Email from Planning officer – Mr Ross Neal. 15/03/2018

I note that your client is now limiting the proposal to single storey 'lean-to' at the side with a set-back of 1m from the front corner of the adjoining dwelling and approximately the same amount from the main front wall of no.52. No first floor extension is proposed. The separation from the adjoining would be 0.85m. The rear extension proposal will remain, this replaces an existing rear conservatory of a similar size, including depth.

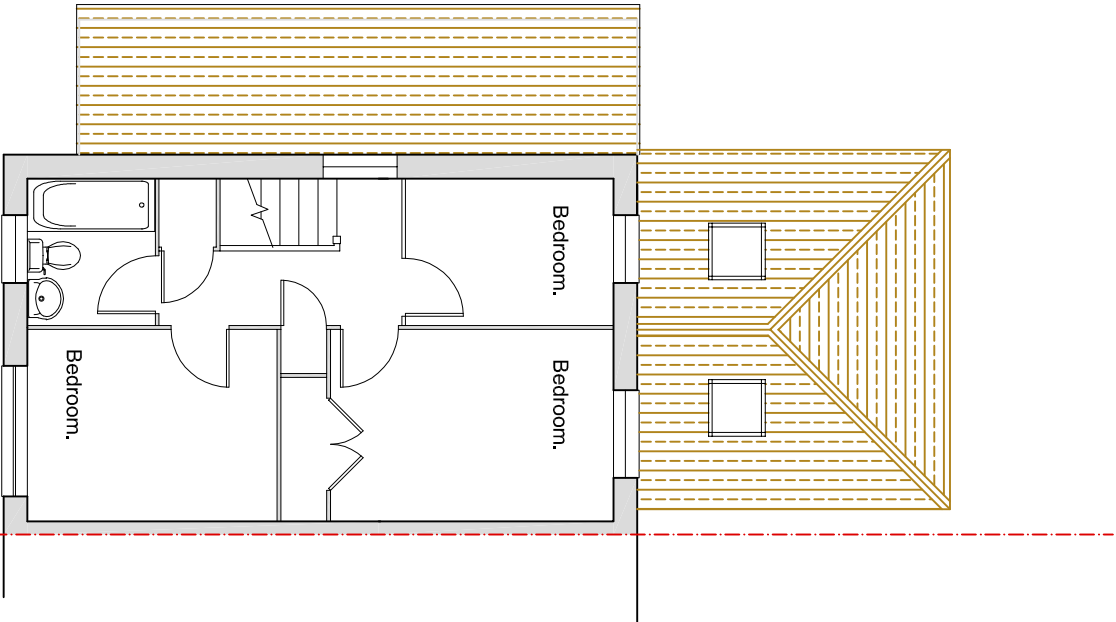
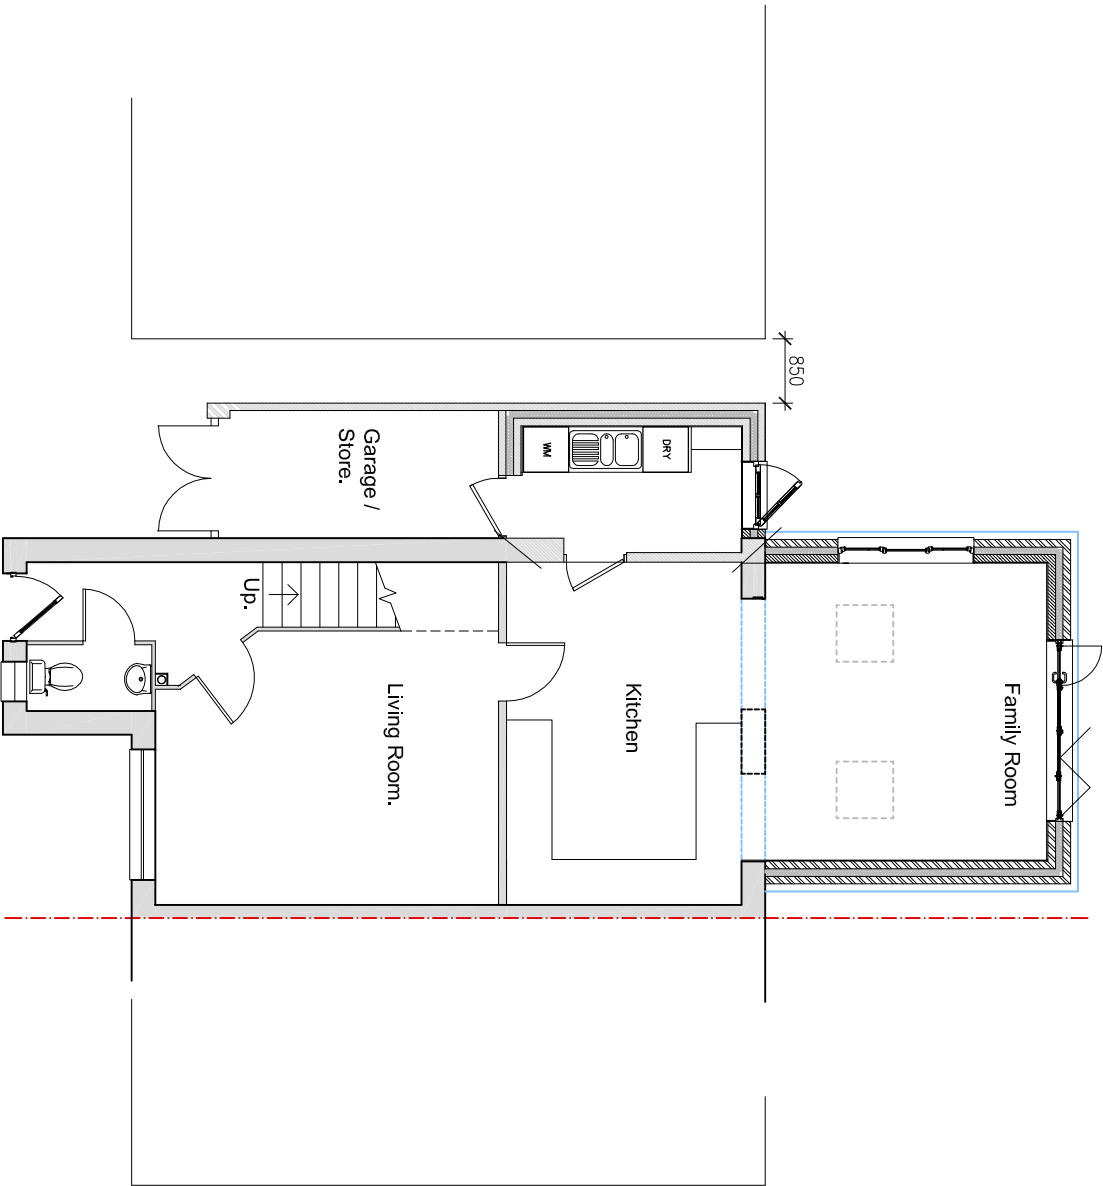
I am of the view that this revised proposal has a substantially reduced impact on the adjoining dwelling and would not result in unacceptably harmful impacts on either no.54 or no.50. In particular, the already limited light into the rear garden of no.54 would be for the most part still available.

I note that the side to side separation will be not be 1m but will be 0.85m. This is an increase from the previous 0.65m. The required 1m separation set out in policy DEV19 (iv) applies to the 1st-floor of 2-storey extensions where streets are characterised by relatively small gaps (in order to prevent a terracing impact visually).

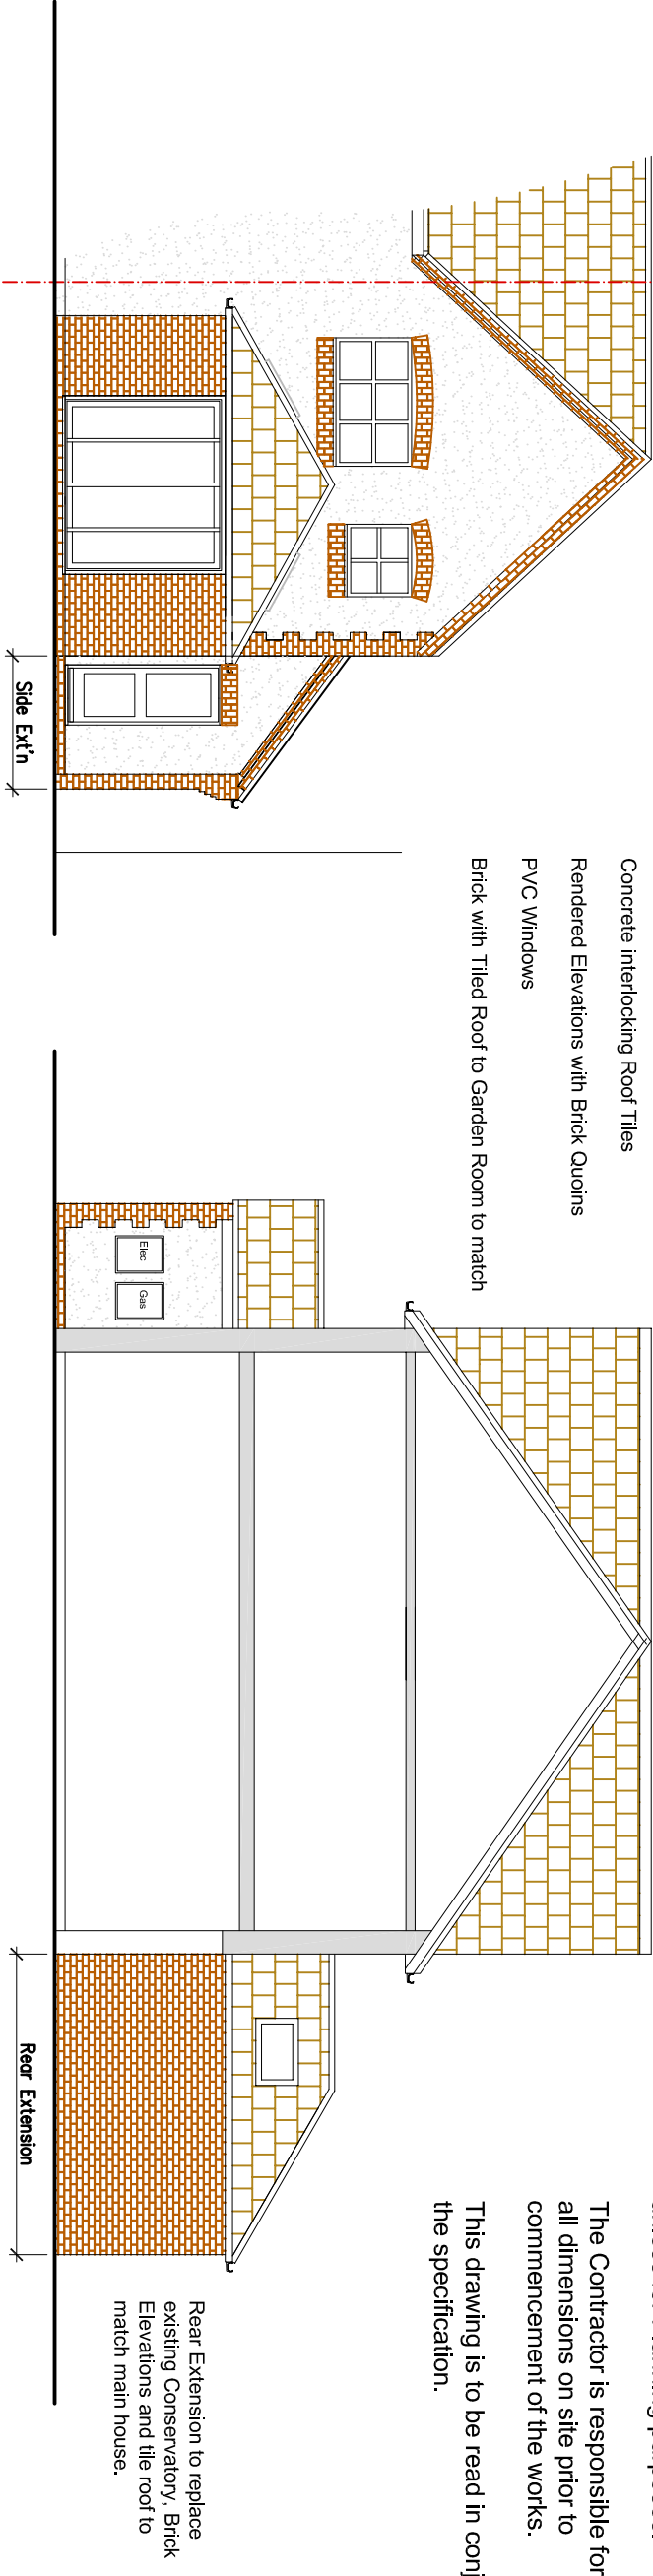
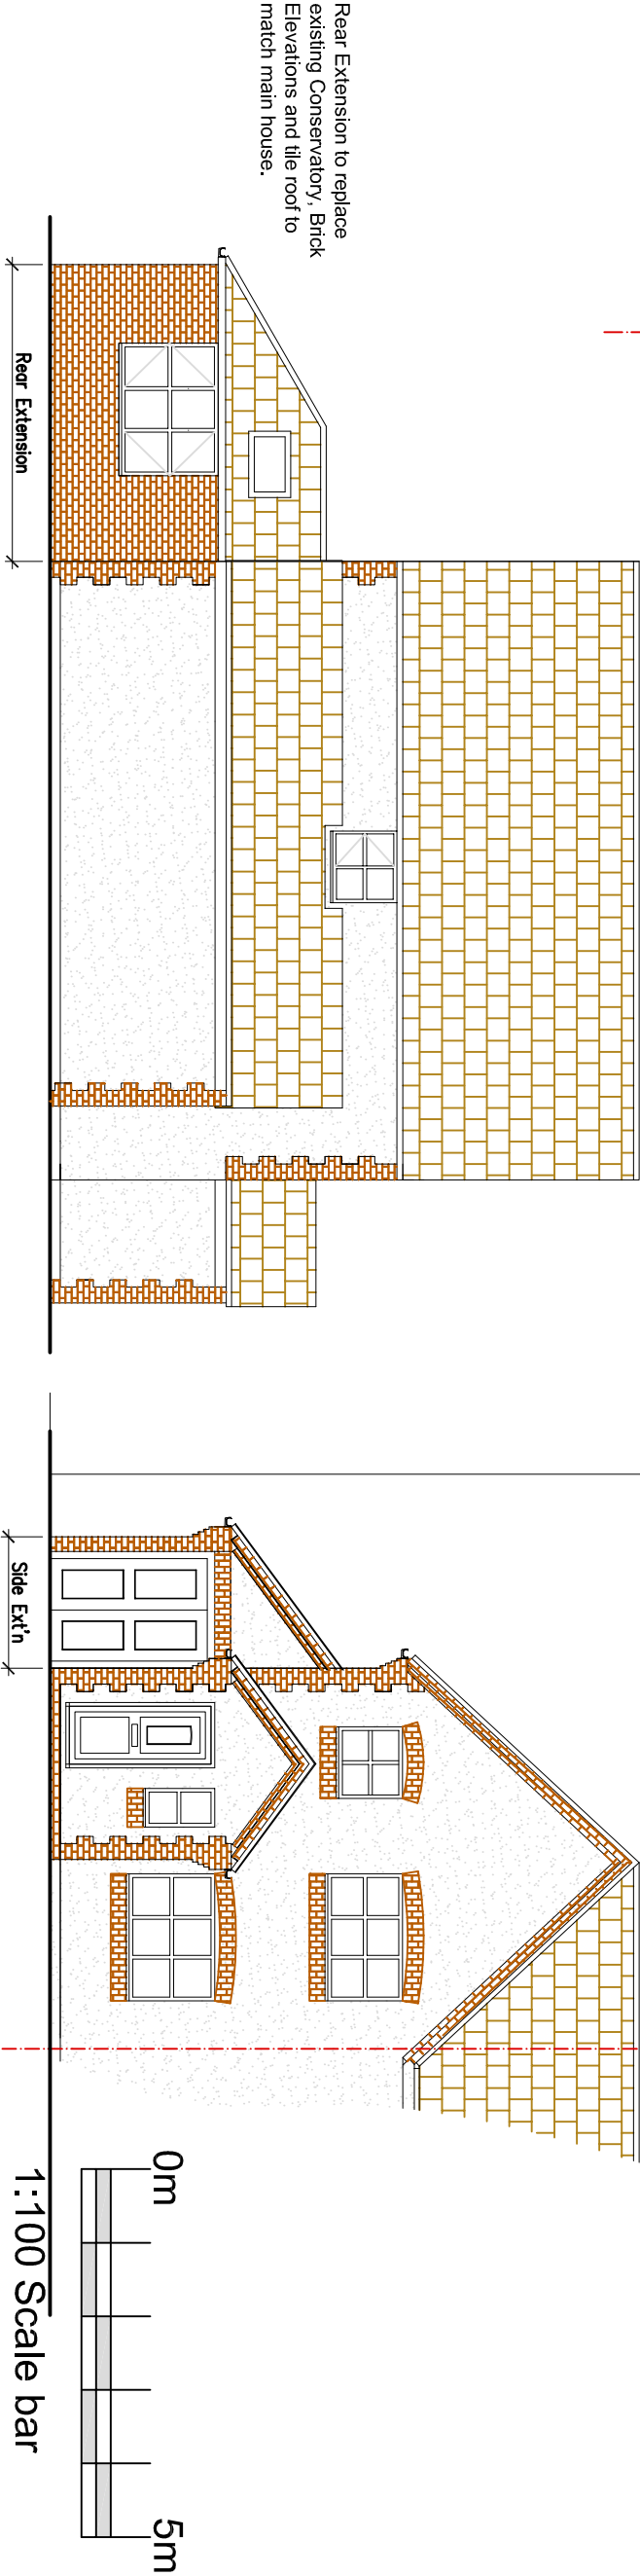
If a first floor extension were to be subsequently proposed above the ground floor as shown in your revised proposal, then as previously discussed this must:

1. Substantially reduce the front eaves level and the ridge level of the extension. This would result in a 'cat slide' type roof at the front, which would still allow some first floor accommodation. The reduced ridge level which can be achieved ought to be significantly lower than the existing ridge level of the dwelling, so as to allow greater penetration of sunlight into the rear garden of no.54.
2. Provide a modest rear dormer with gable and ridged roof. This would allow for space in the first floor bedroom.

On this above basis and subject to seeing the final detailed design of any first floor extension, I would consider that the separation at 0.85m (0.15m less than the policy) would, taken with the other revision (1 & 2 above), be acceptable and that there would not be sufficient grounds to refuse such an application.
